August 7, 2024

Re: Mercado el Milagro Bldg. D
10000 Central Ave. SW
30-Day Temporary Certificate of Occupancy
Transportation Development Final Inspection
Architect's Stamp dated 07-08-21 (L09-D042A)
Certification dated 07-29-24

SHEET NO:
A1.2

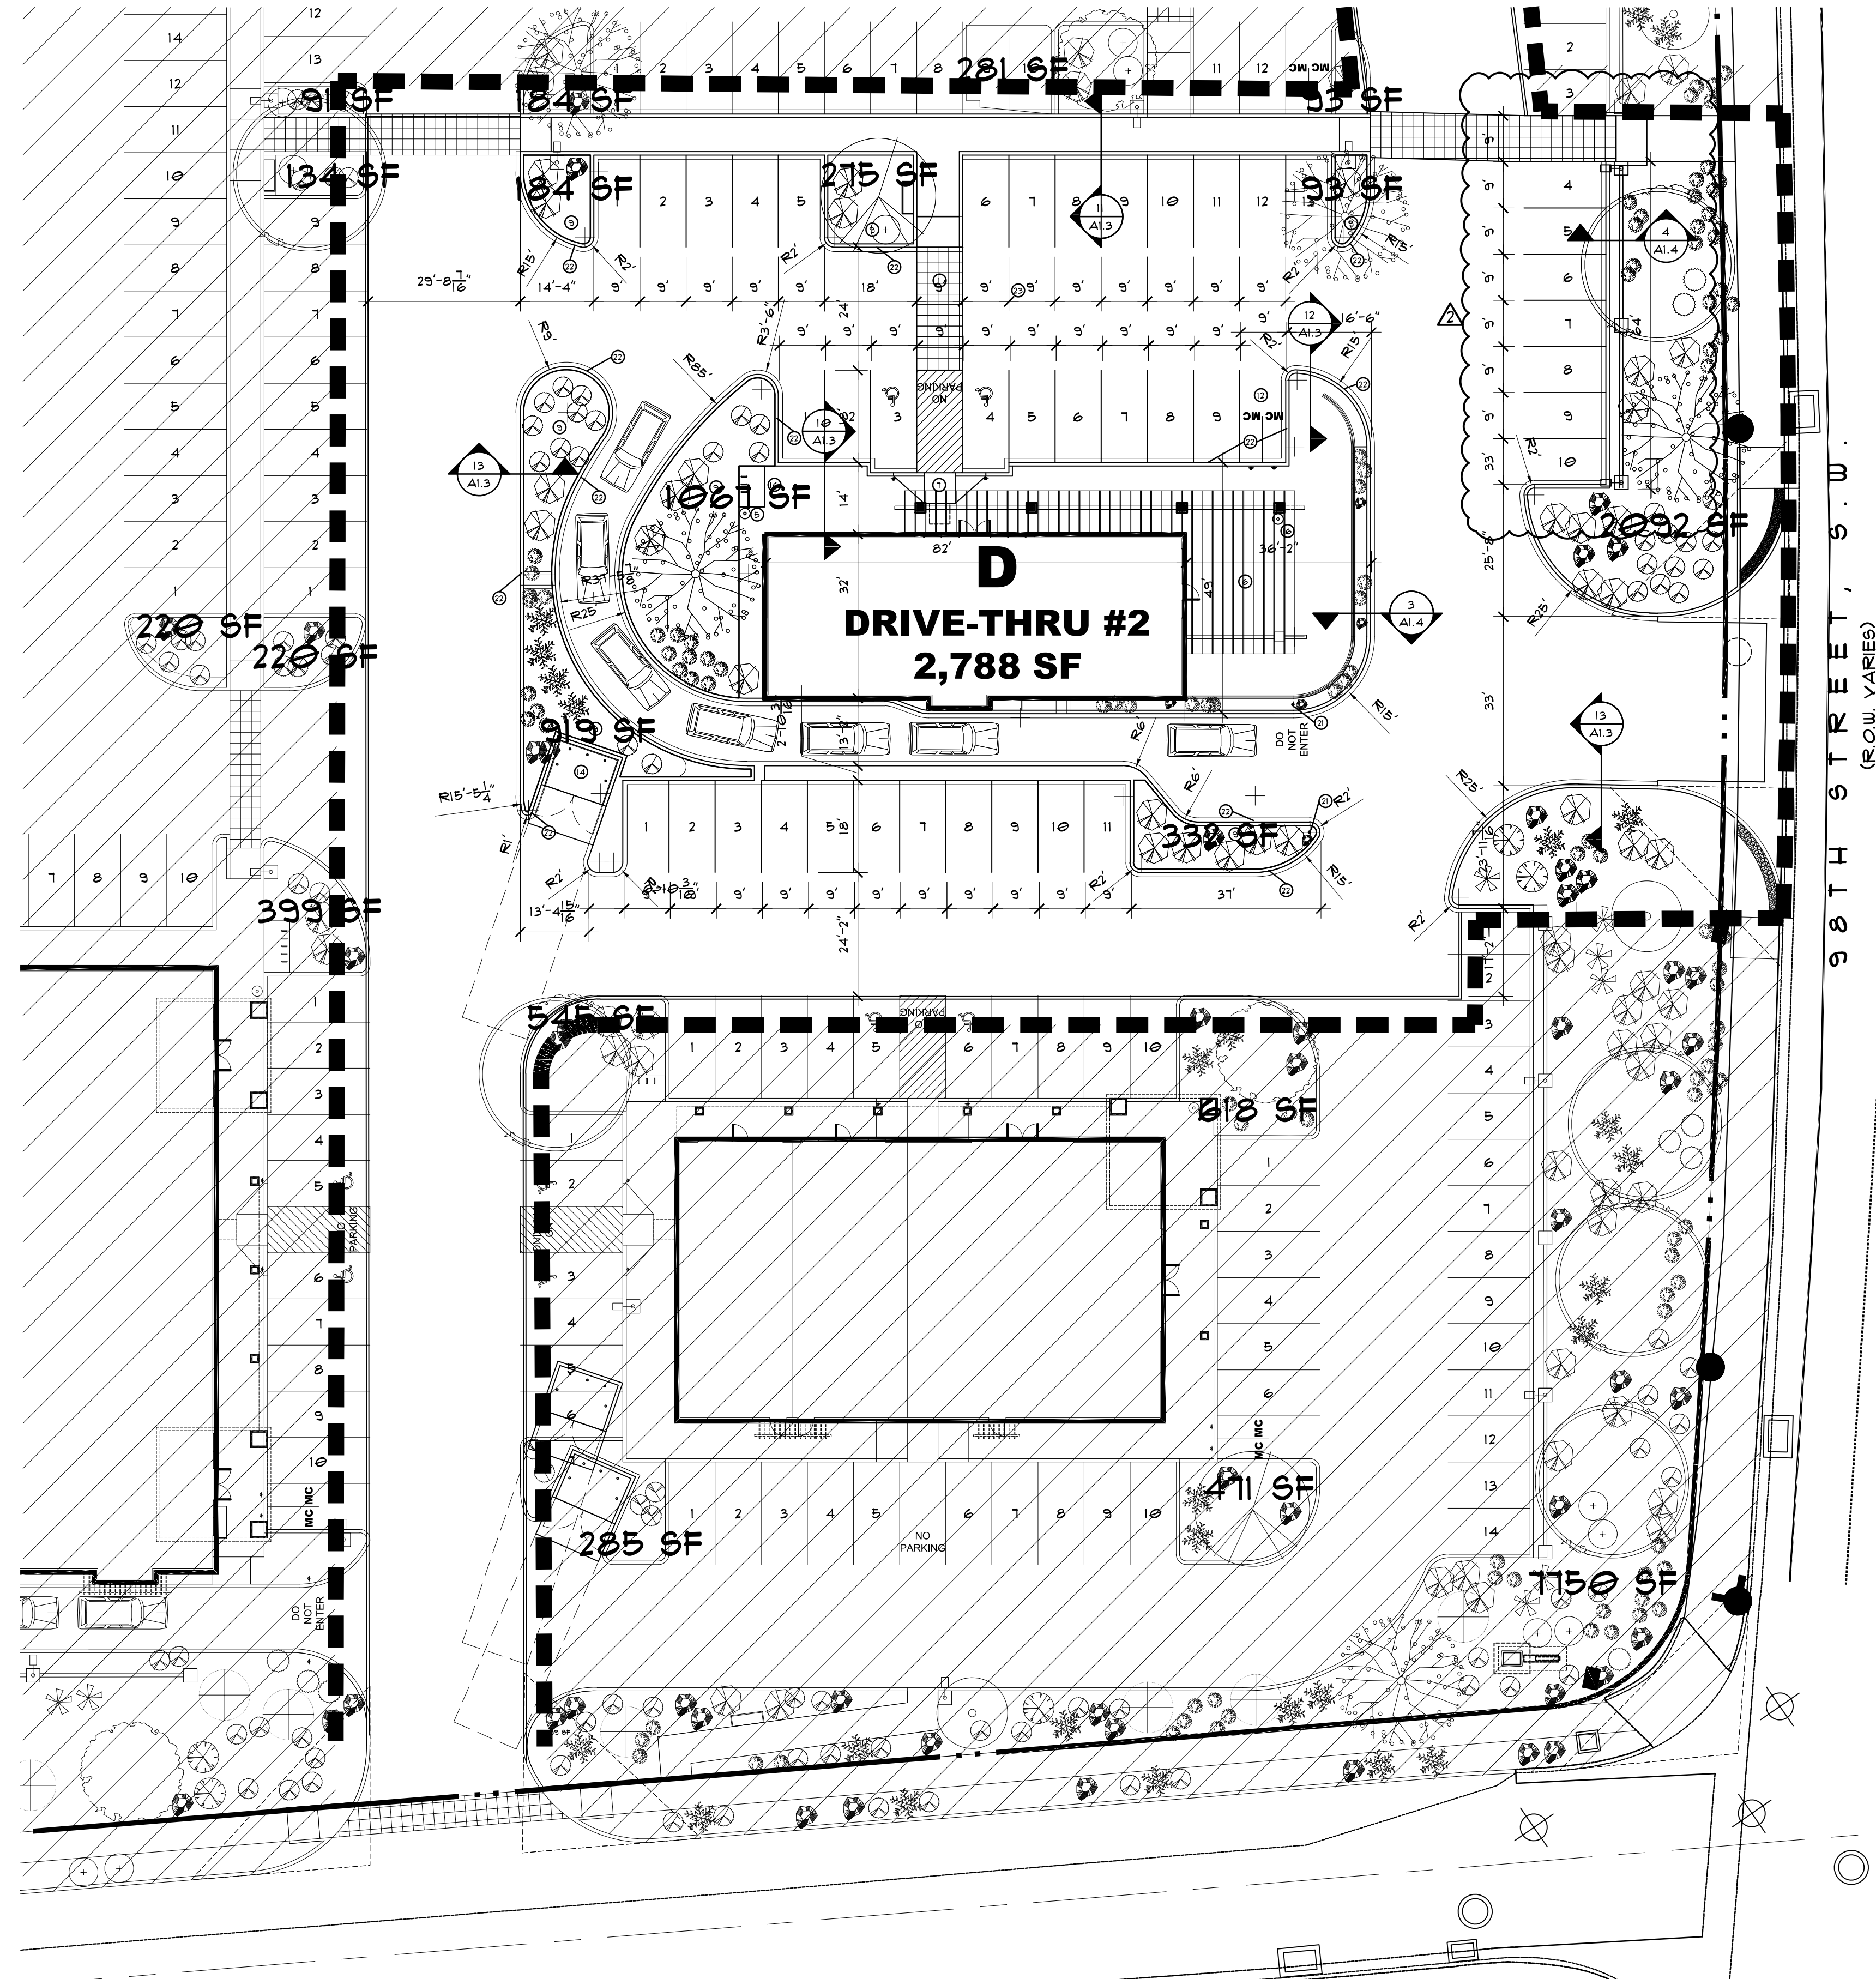
- Due to the closed gate, I was unable to check the parking, drive aisle dimensions, and the ADA ramp slope. Please email Marwa Al-najjar at malnajira@cabq.gov to schedule a follow-up site visit.
